From: Iqraa Malik
Sent: 01 December 2020 15:09
To: Sian Eggington
Subject: FW: Attn Sian Eggington Request for further information AB/125/20/L
Attachments: We sent you safe versions of your files; Actual Floor plan 19 Maltravers Street.pdf; Actual floorplan only.xlsx

19 Maltravers Street, Floorplan

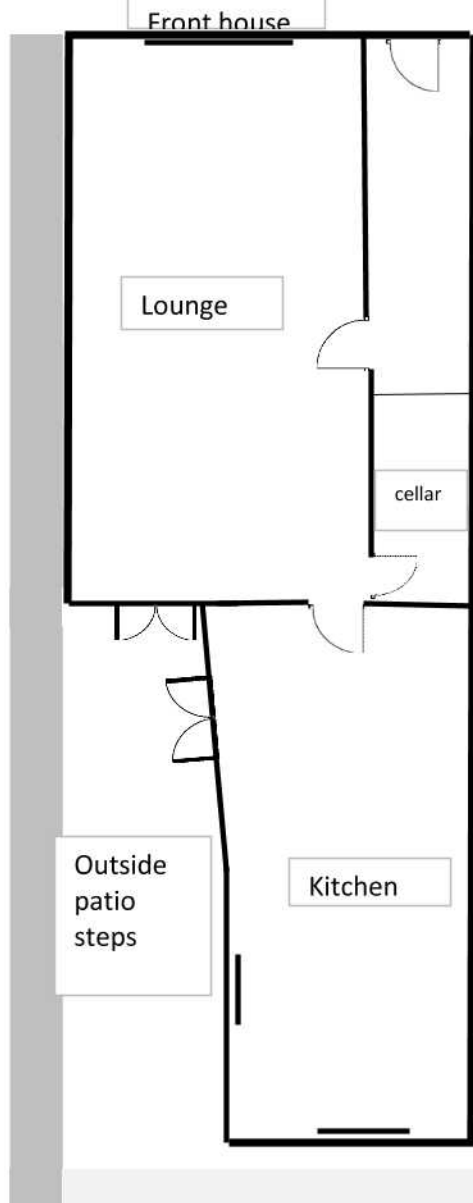
Could you please confirm the scale as I'm measuring it at 1:100 and this is what it's showing it as. As the drawing is scaled 1:100, 1cm= 1:100 so if the proposed extension is for example 1.8m by 3.6m it would be shown as 1.6cm x 1.4cm

The measurements on this new plan appear to be the same as the old?

No worries. I've had a quick look over the floor plan and it doesn't measure to the 1:100 scale listed on the plan. I've attached a screenshot below. Please amend.

Please add room labels to your floor plans so we are able to process and validate this application.

Floor Plans: Please add room labels.

The extension is 360cm which is 3.6cm at 1:100 by 184cm which Ive done at 1.8cm

Clearly converting it a PDF to fit one page has distorted it.

The measurements attached are exactly what excel is showing ie 3.6 cm and 1.8cm across for the extension.

19, Maltravers Street, Arundel, West Sussex, BN18 9AP
Scale 1:200

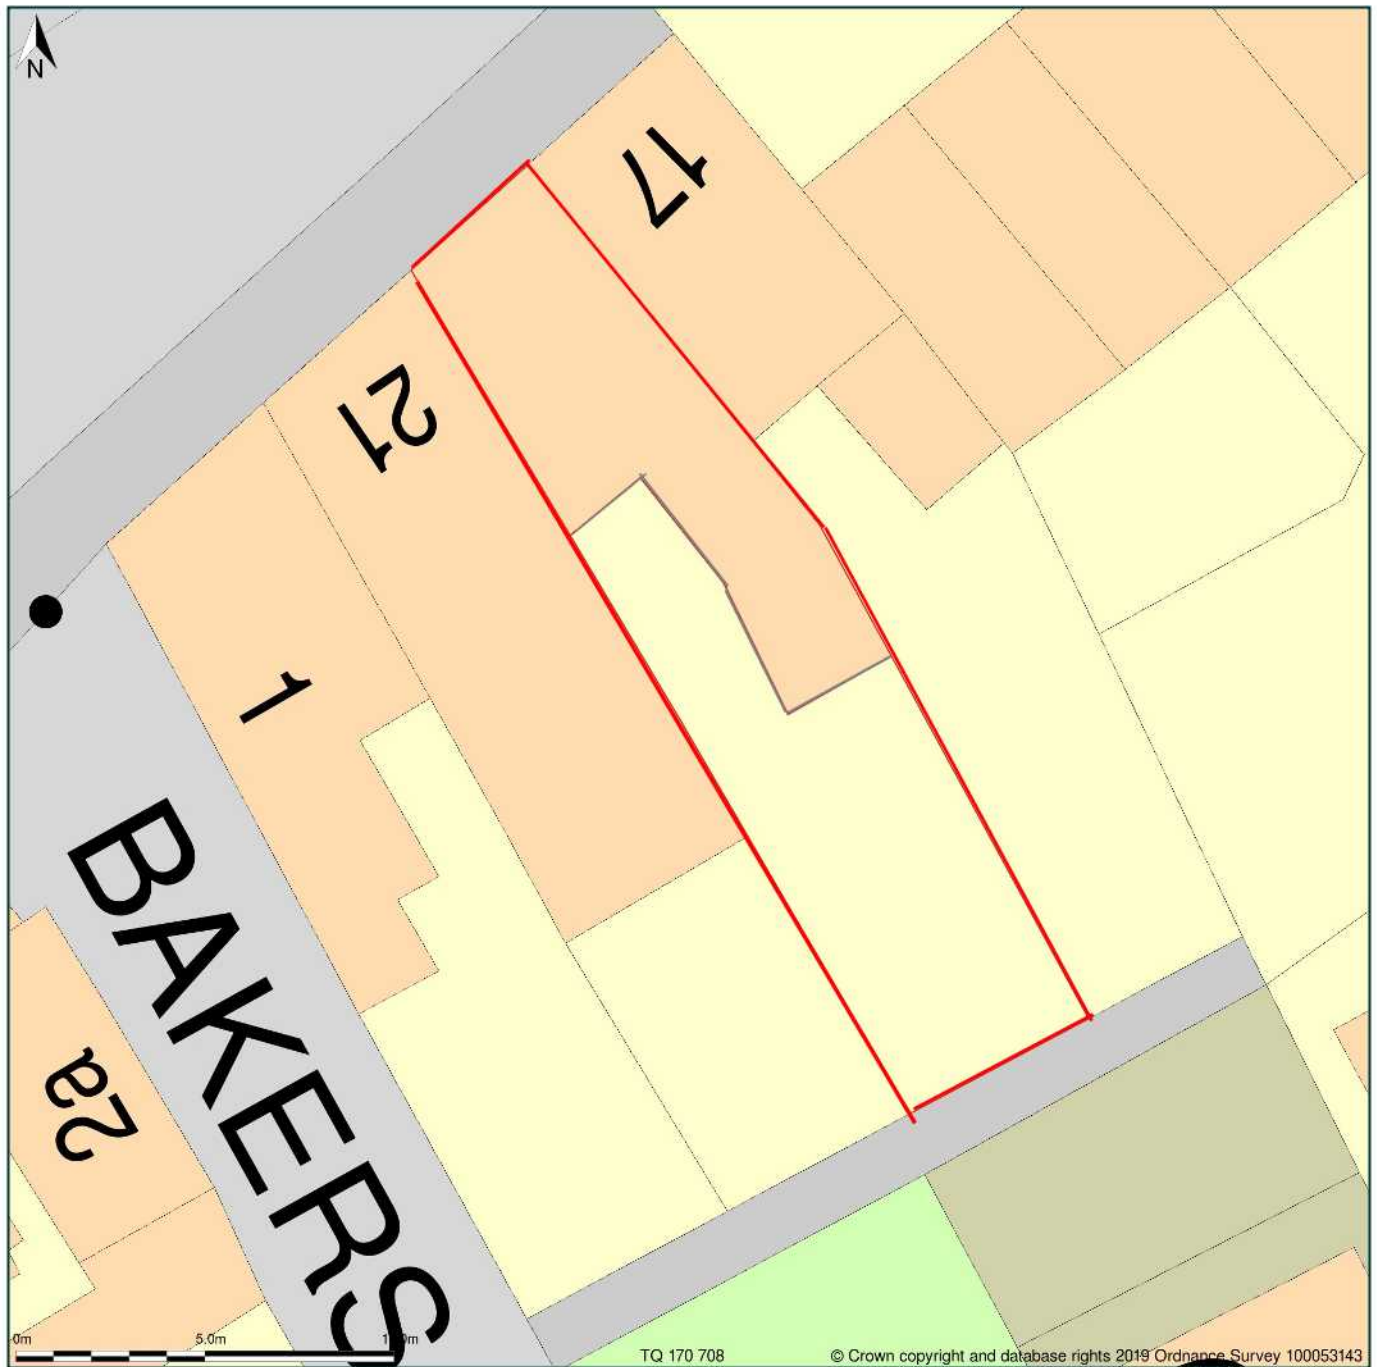
Block Plan: The red line on this must match the one on the location plan, please amend.

Block Plan: This must also be in PDF format with dimensions from the proposed extension to the site boundaries. Please amend.

The company I used sent me the location plans with the house boundary also in red. Ive managed to get that changed as per your instructions and I hope they are correct now.

Elevation of external kitchen door removal
Scale 1:50
Current side elevated view

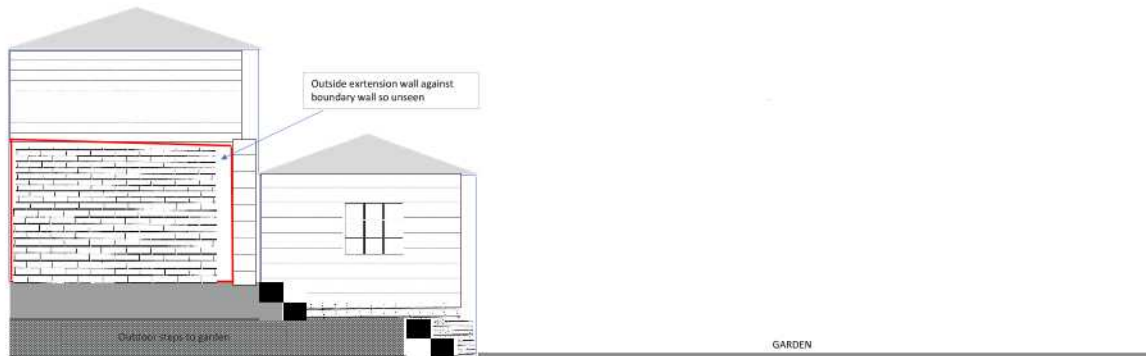
Elevations: We will also require the side elevation where you'll be removing the door.
